Date: 3 July 2024

Application by Total Energies and Corio Generation for an Order Granting Development Consent for the Outer Dowsing Offshore Wind Project

Request for further information

Scale	1:5000	Designed	JR	Drawn	JR	Checked		Authorised	JR
Original Size	A1	Date	20.07.23	Date	20.07.23	Date	20.07.23	Date	20.07.23
Drawing Number	VD23907	Project Ref. No.	VD23907	Location	001	Type	-DR-CH-	Number	0010
Revision	P06

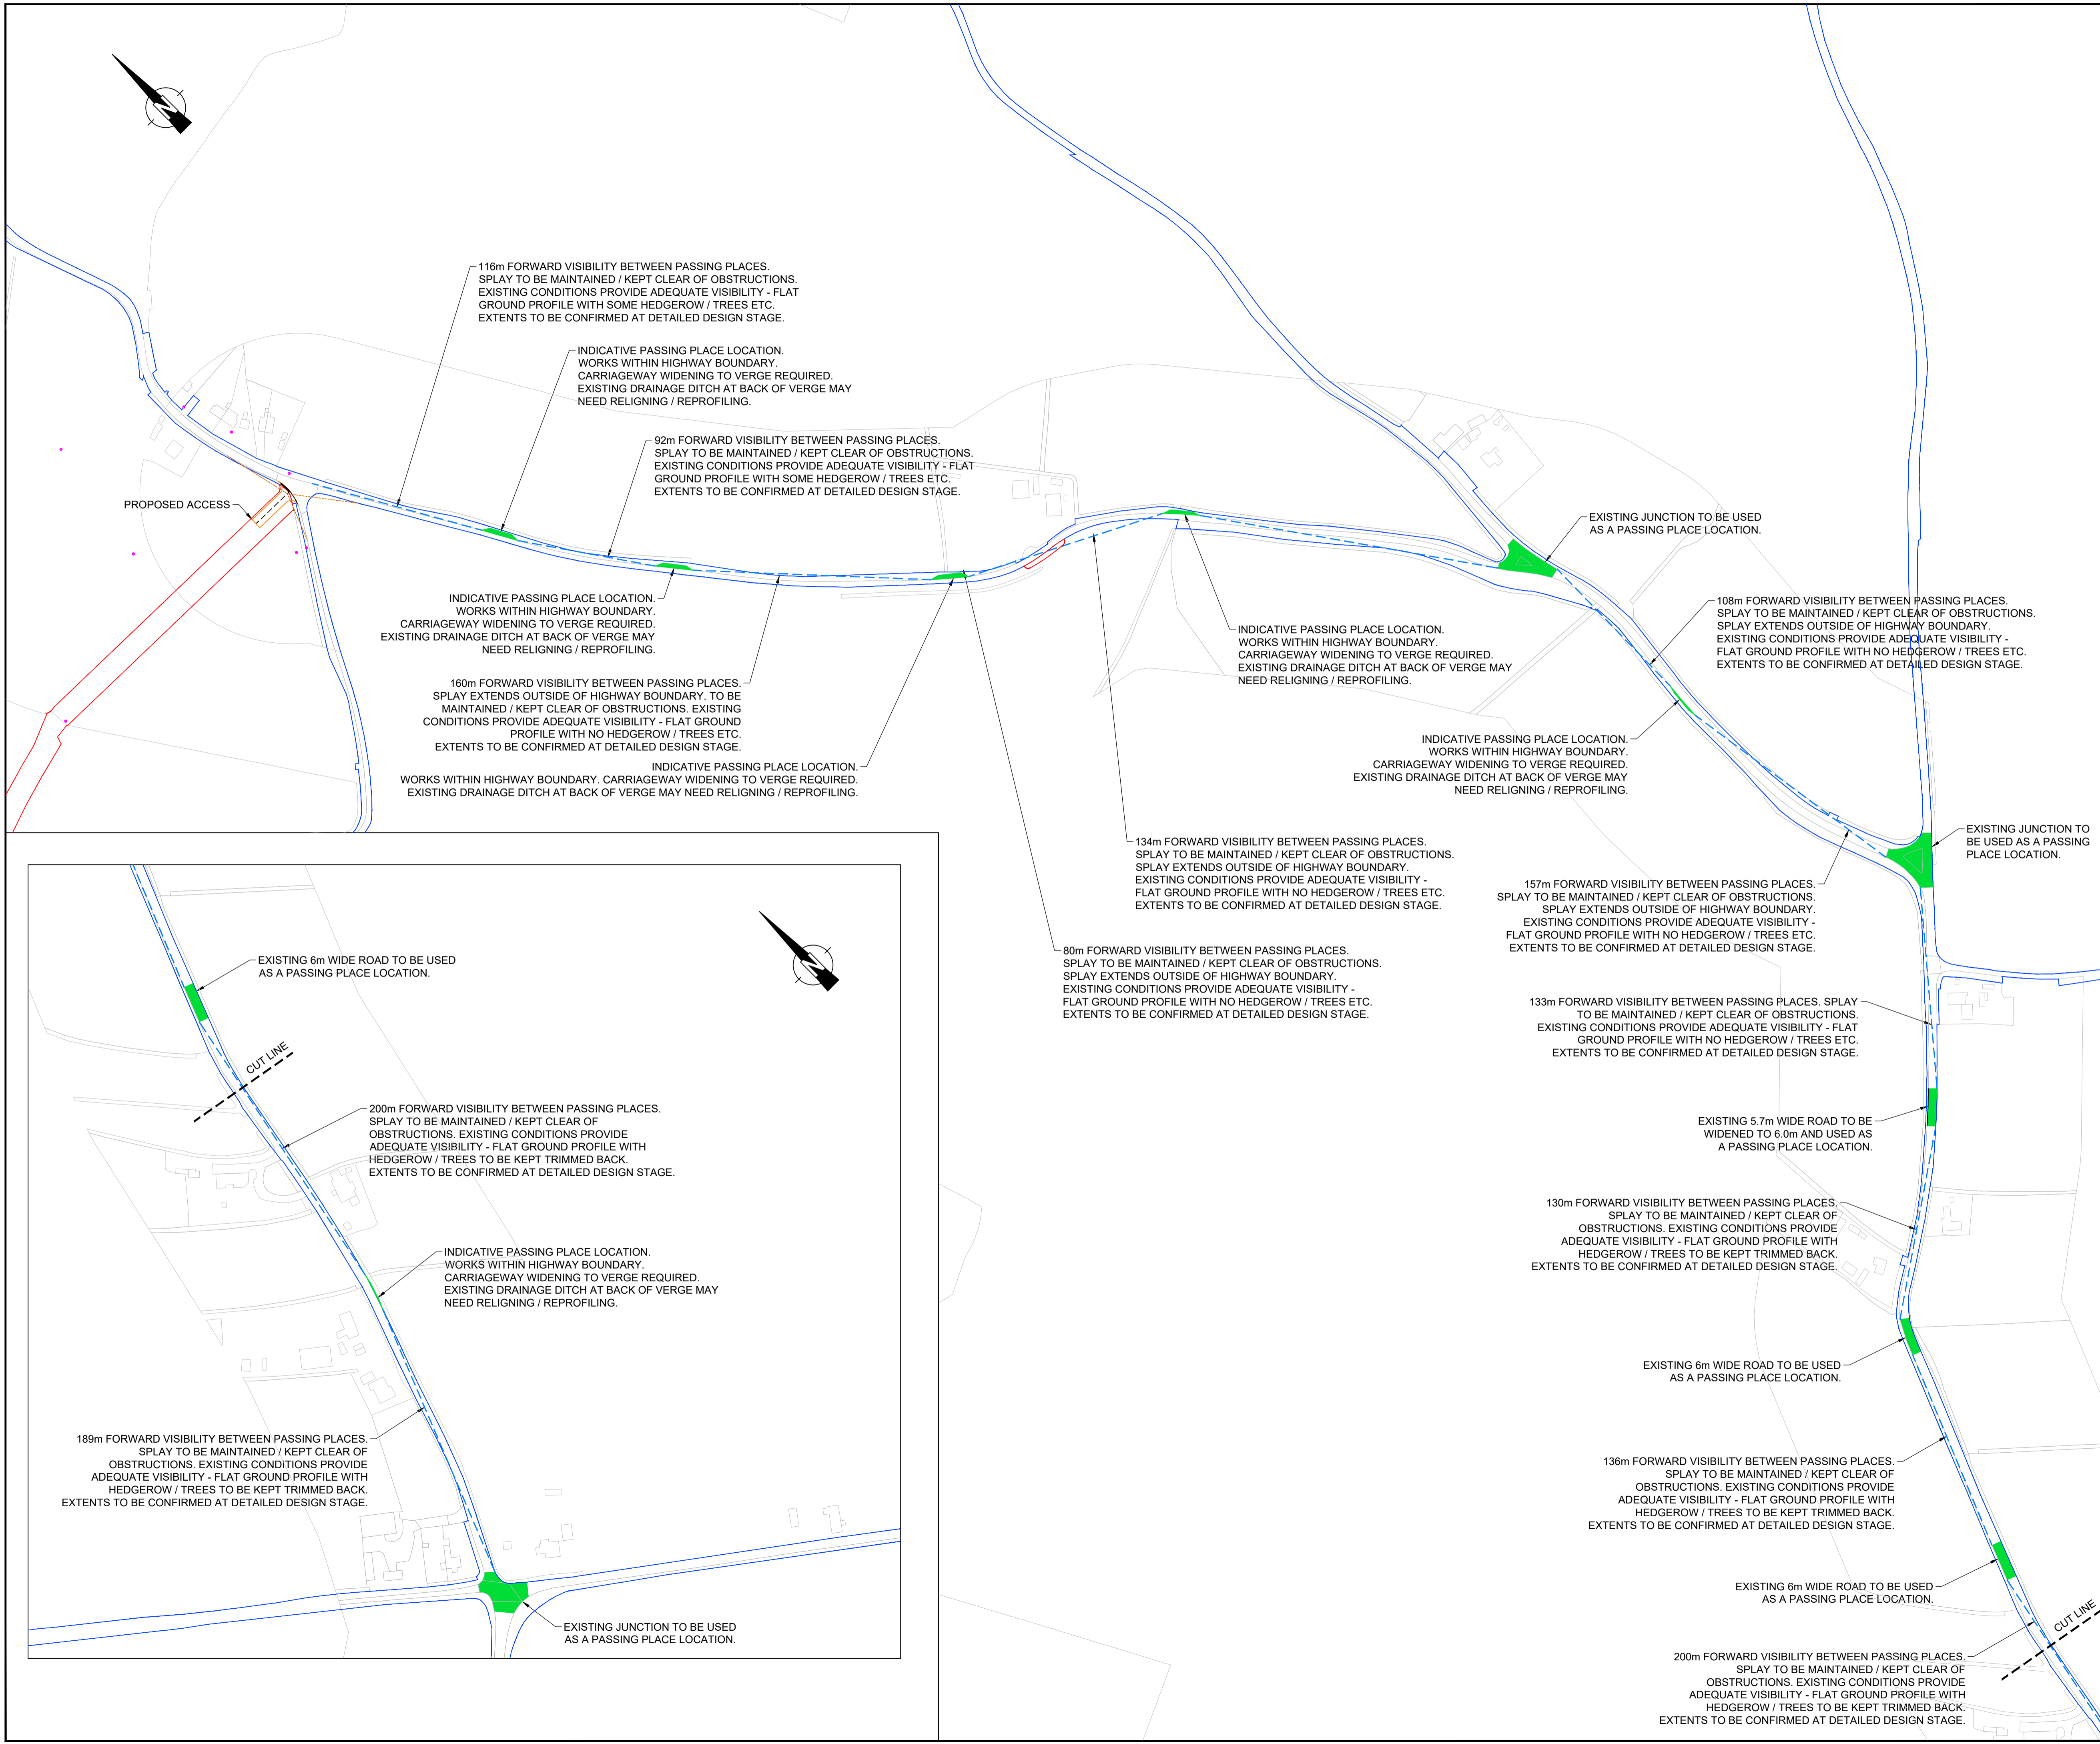
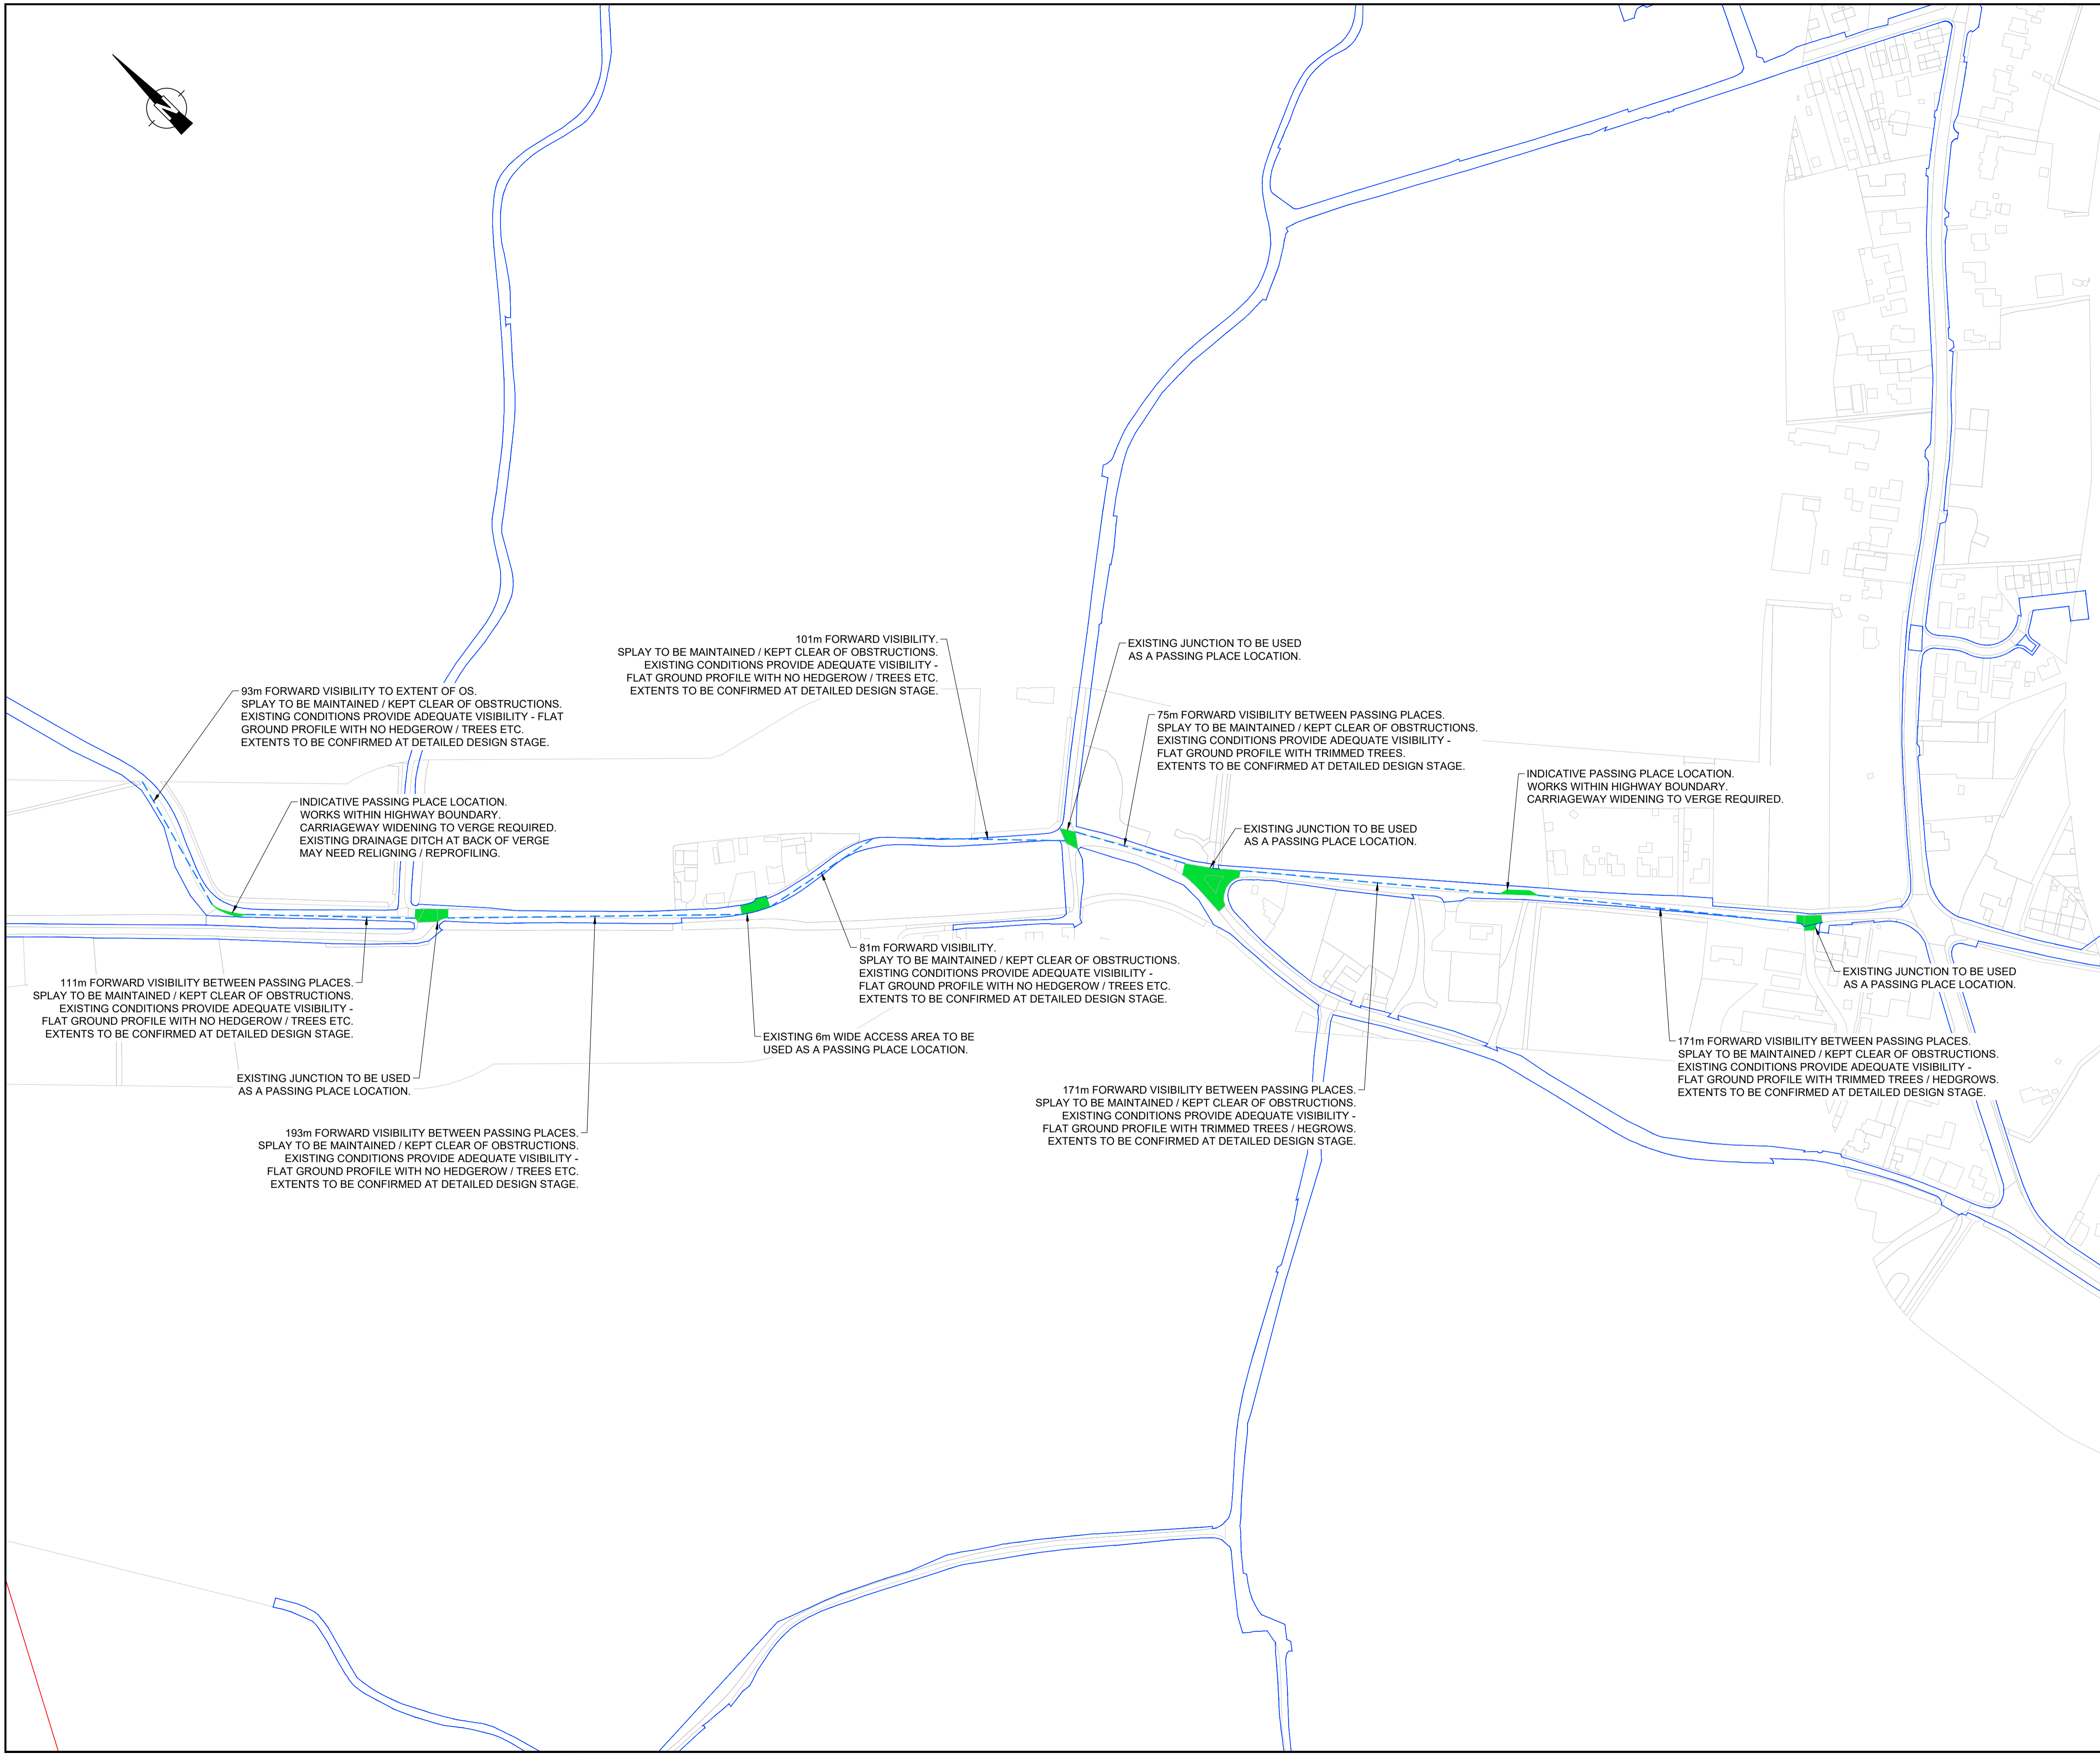
ES Chapter 27 Appendix 1 Transport Assessment Annex N Passing Place Proposal [APP-229] - As shown on page 2, the detailed drawing titled 'Location Reference 002 Boston' appears to be missing. The Applicant is requested to correct the drawing title on page 12 and check the consistency of Location Reference 015 as shown on page 2 with the drawings on pages 13 and 14.
